**Addendum No. 1**

RE: Contract # C203847

**Rutherford County (B-5397)**

Bridge # 51 Over Floyds Creek On SR-2213

GENERAL DRAWING  
 FOR BRIDGE  
 OVER FLOYDS CREEK  
 ON SR 2213 BETWEEN  
 SR 2168 AND SR 2264

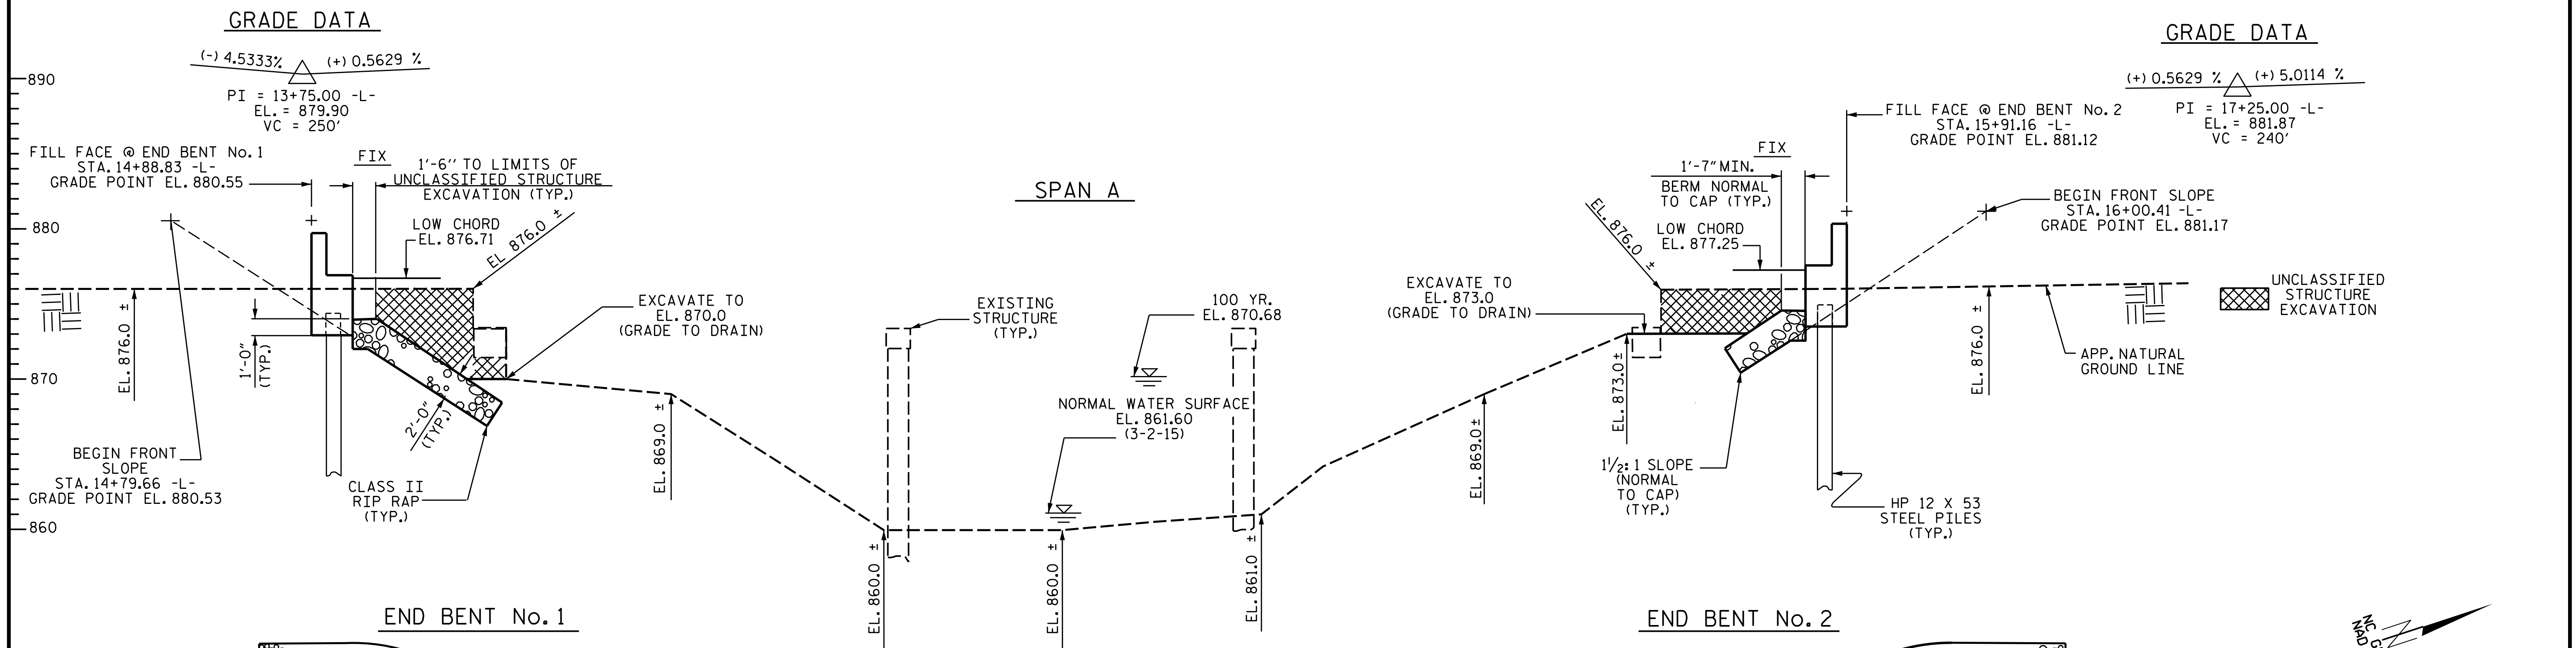
Sheet No.	Revisions
Title Sheet	The let date on the Roadway Title Sheet has been revised
Title Sheet	The let date on the Structures Title Sheet has been revised

Please delete the Title Sheets in your plans and staple the revised Title Sheets thereto.
